1 September 2006

Gosford City Council

Major Projects Assessment
Dept of Planning & Infrastructure
GPO Box 39
SYDNEY NSW 2001

**Environmental Assessment: Proposed 50 Berth Marina Lot 519 DP729020 No 19
Brisbane Water Drive Koolewong (10_0209)**

Fig 4

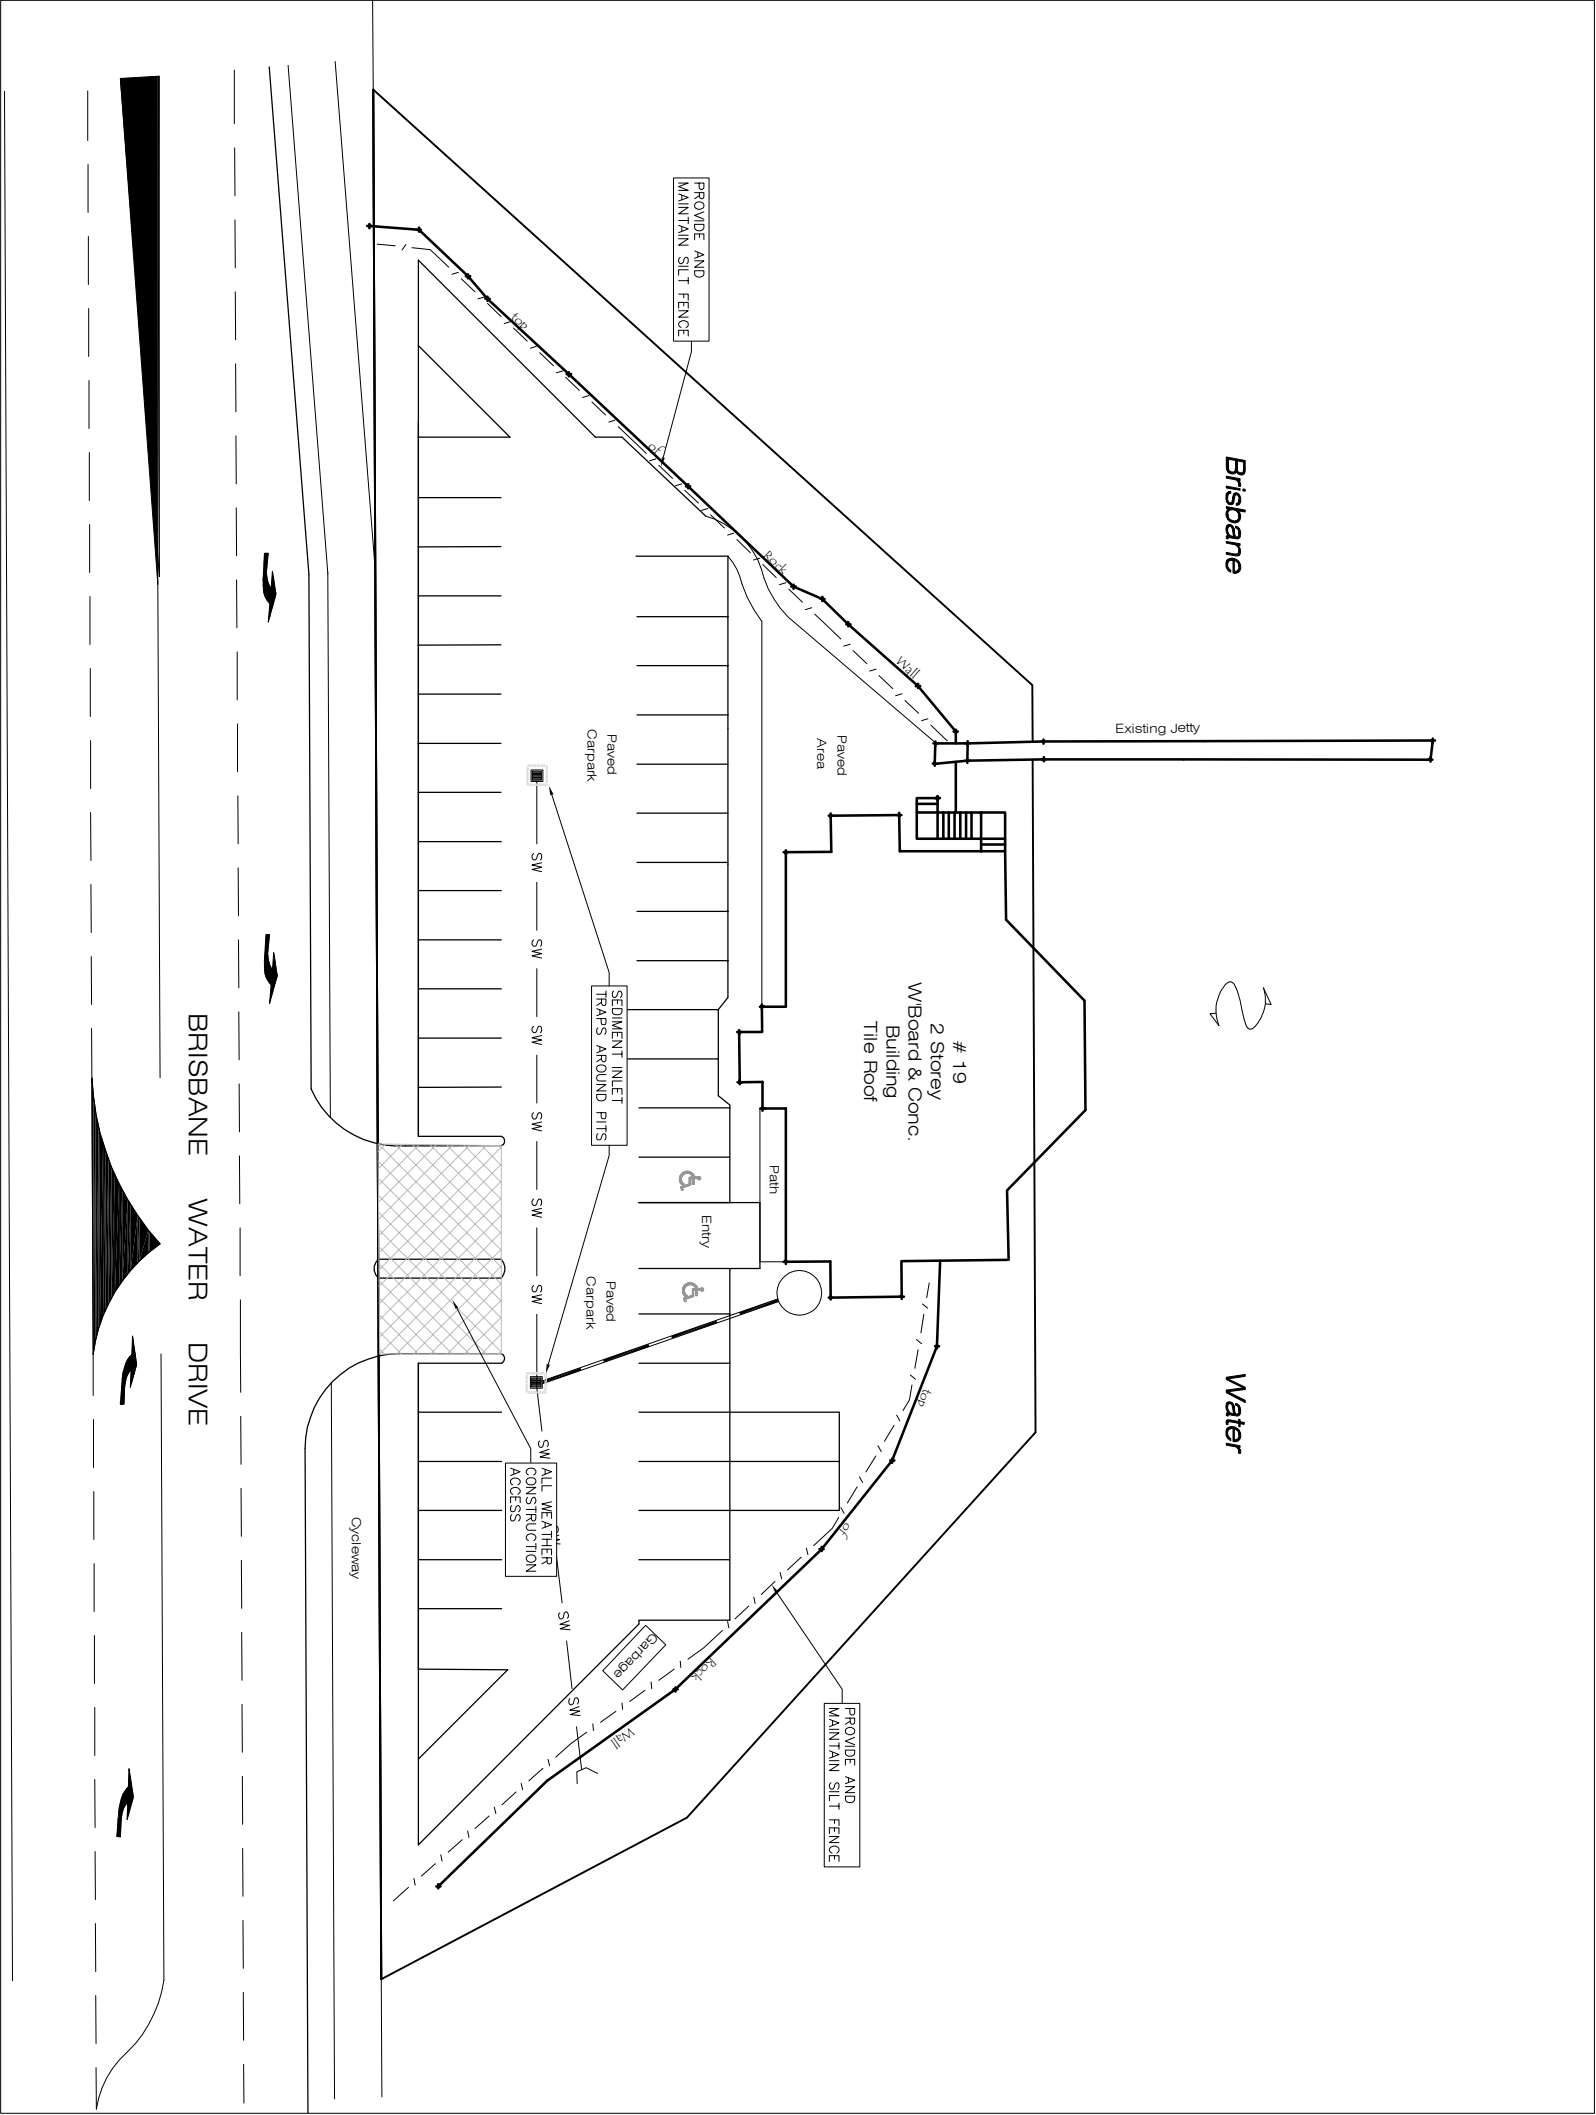
- (c) The provision of additional parking spaces to comply with that needed for the Marina relies on extension of the paved car parking area onto the rock wall. This will require certification of the structural adequacy of the sea wall and the construction of safety barriers to prevent vehicles accidentally falling into the water.

Council's letter of 9/12/2010 stated that any proposal to expand fill into Brisbane Water or expand the paved area must be contained within the site area and supported by a geotechnical report. This does not appear to have been done. Such expansions of the paved area may result in the structural e

failure at the edge or require some form of retaining wall to achieve what is proposed.

A nutrient control facility must be provided to prevent nutrients/oils from the car parking area directly flowing into Brisbane Water.
